United Utilities Water PLC
Developer Services & Planning
Thirlmere House
Lingley Mere Business Park
Lingley Green Avenue
Great Sankey
Warrington WA5 3LP

Your ref: 3/2012/0910
Our ref: DC/12/4346
Date: 12-NOV-12

Location: Bridge Heywood Caravan Park, Dunkirk Farm, Whalley Road, Read
Proposal: site of 15 new static holiday caravans in place of the storage area

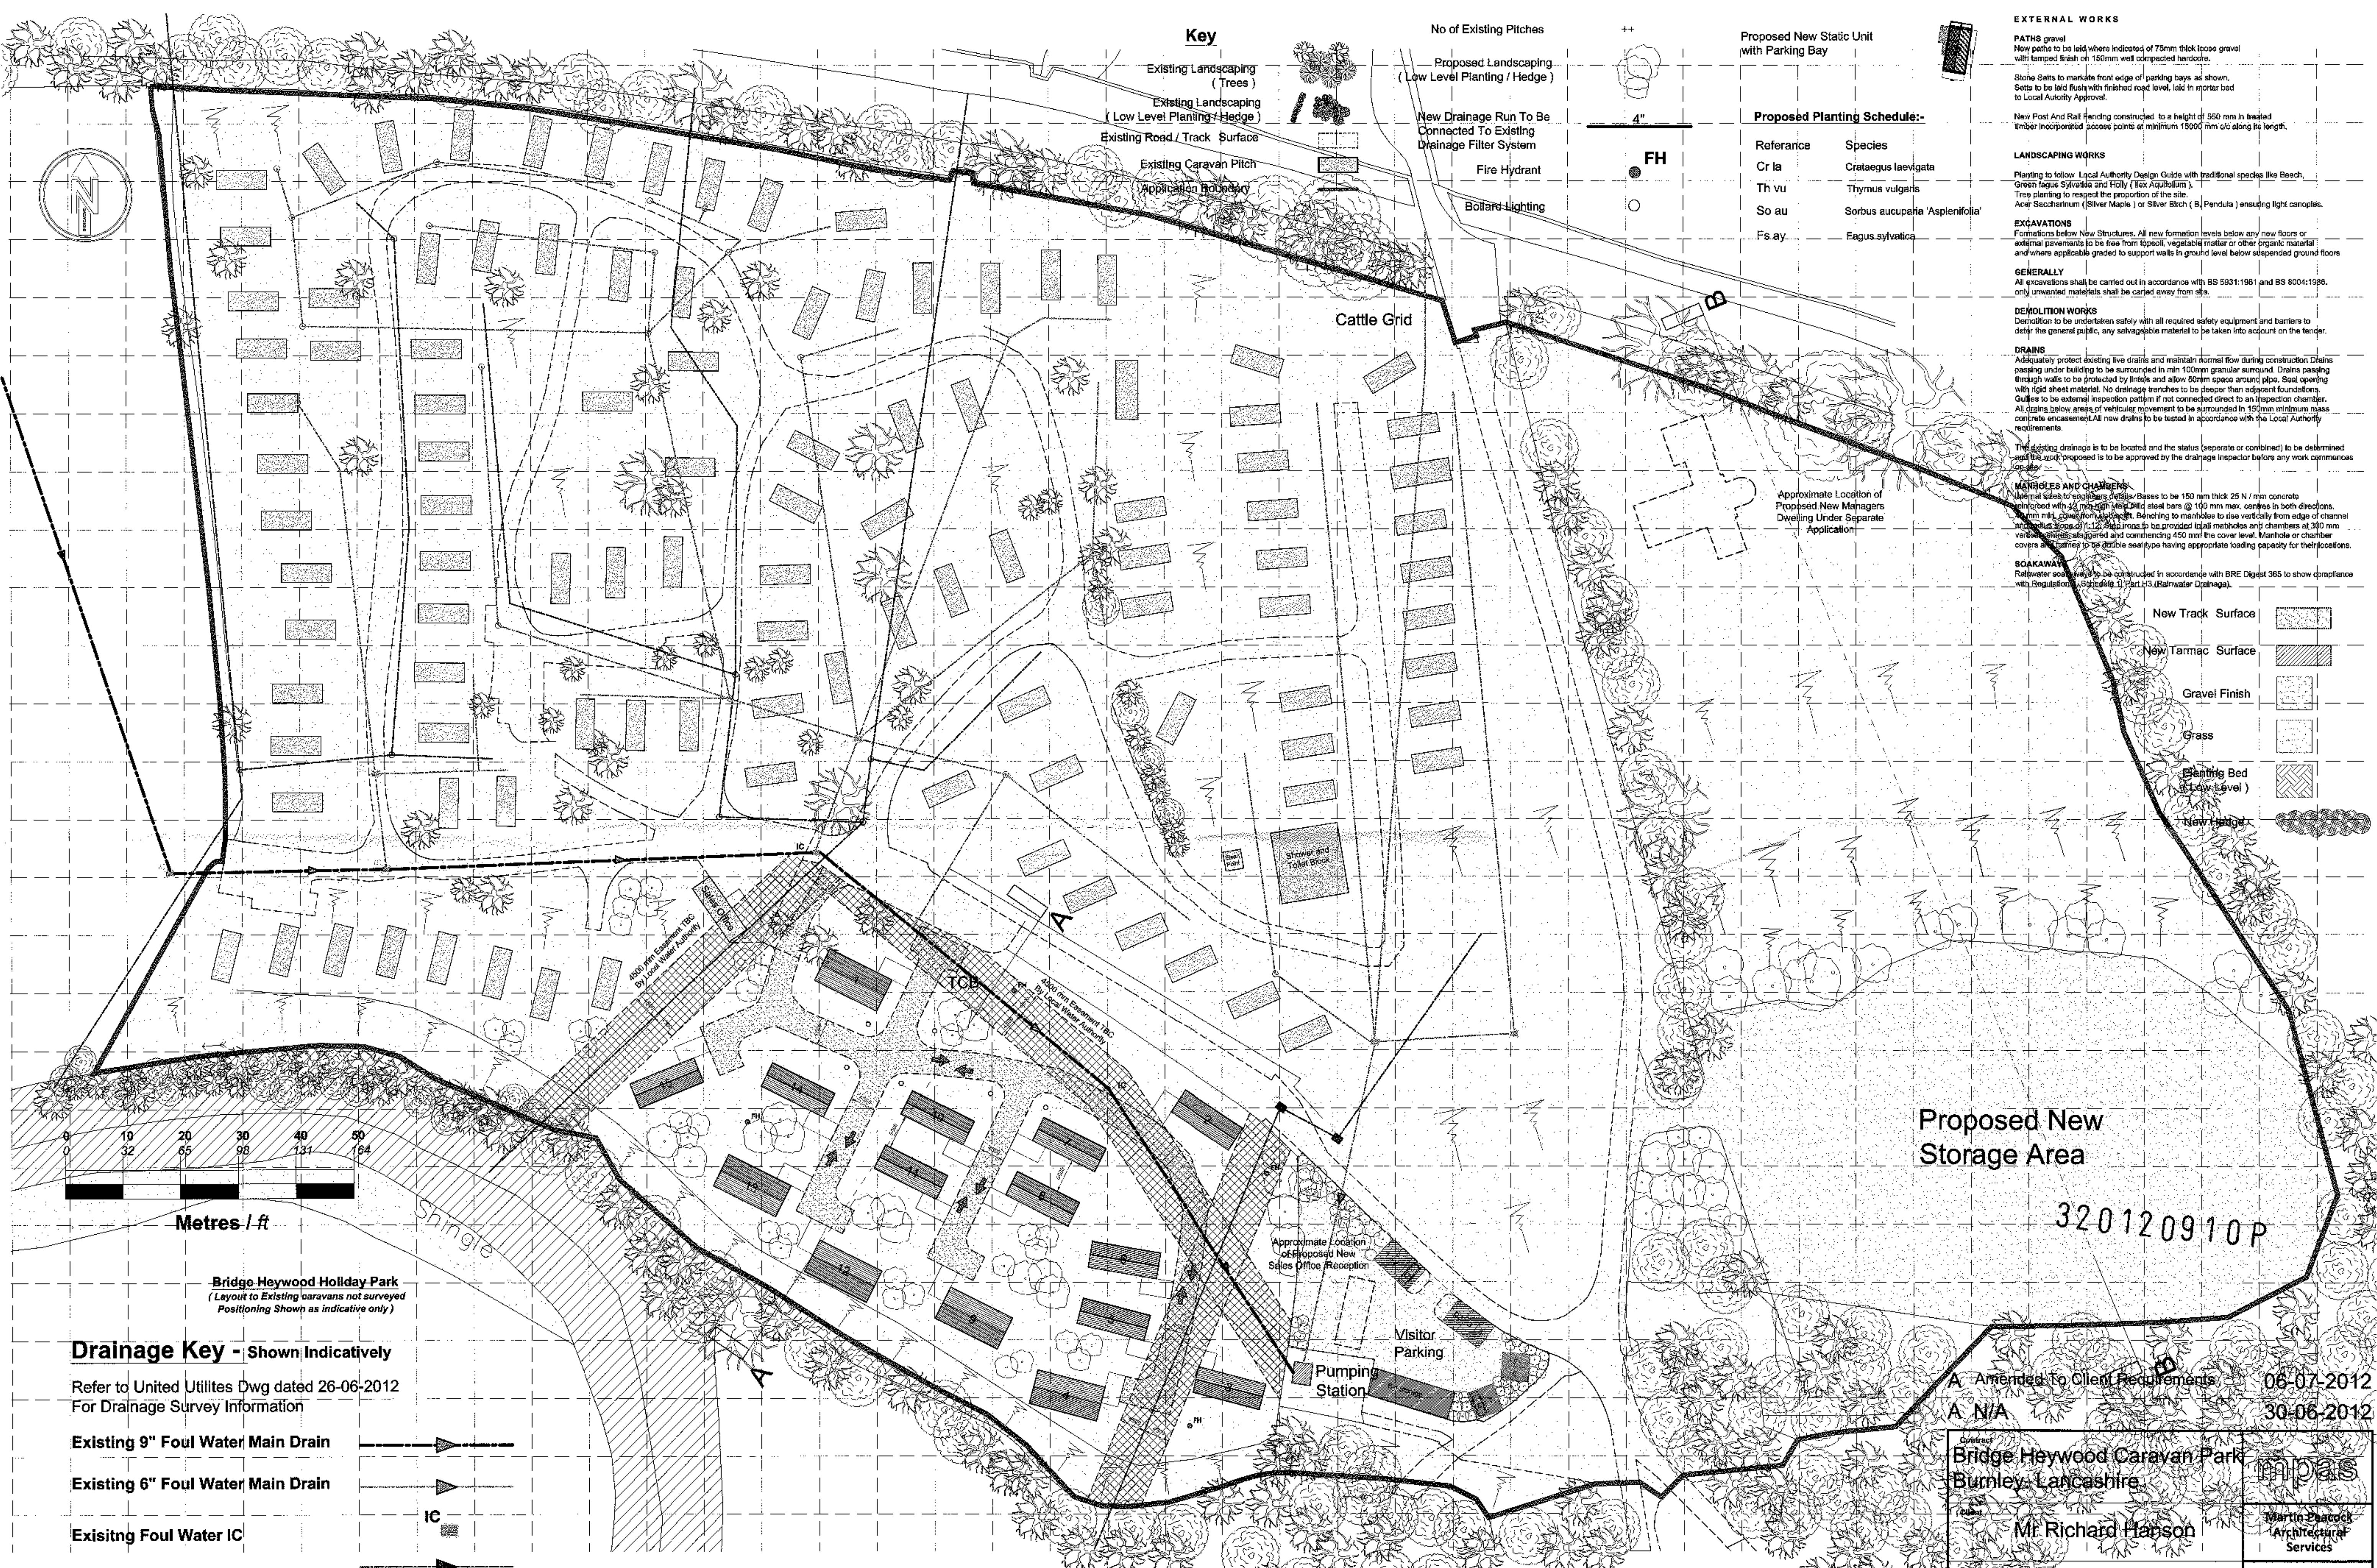
This site must be drained on a separate system, with only foul drainage connected into the combined sewer. Surface water should discharge to the soakaway or directly to watercourse which may require the consent of the Local Authority. Surface water should not be allowed to drain to the public sewer as there are adequate alternative methods of surface water drainage available.

A public sewer crosses this site and we will not permit building over it. We will require an access strip width of 6 metres, 3 metres either side of the centre line of the sewer which is in accordance with the minimum distances specified in the current issue of "Sewers for Adoption", for maintenance or replacement.

We would encourage the planning authority to dissuade the developer from erecting habitable buildings within 15m of the existing pumping station. This is to reduce the risk of noise, vibration & odor pollution and to improve the quality of life of future occupants.

- Notwithstanding any indication on the approved plans, no habitable buildings shall be erected within 15m of the existing foul pumping station located at Grid Reference:375863,433934.
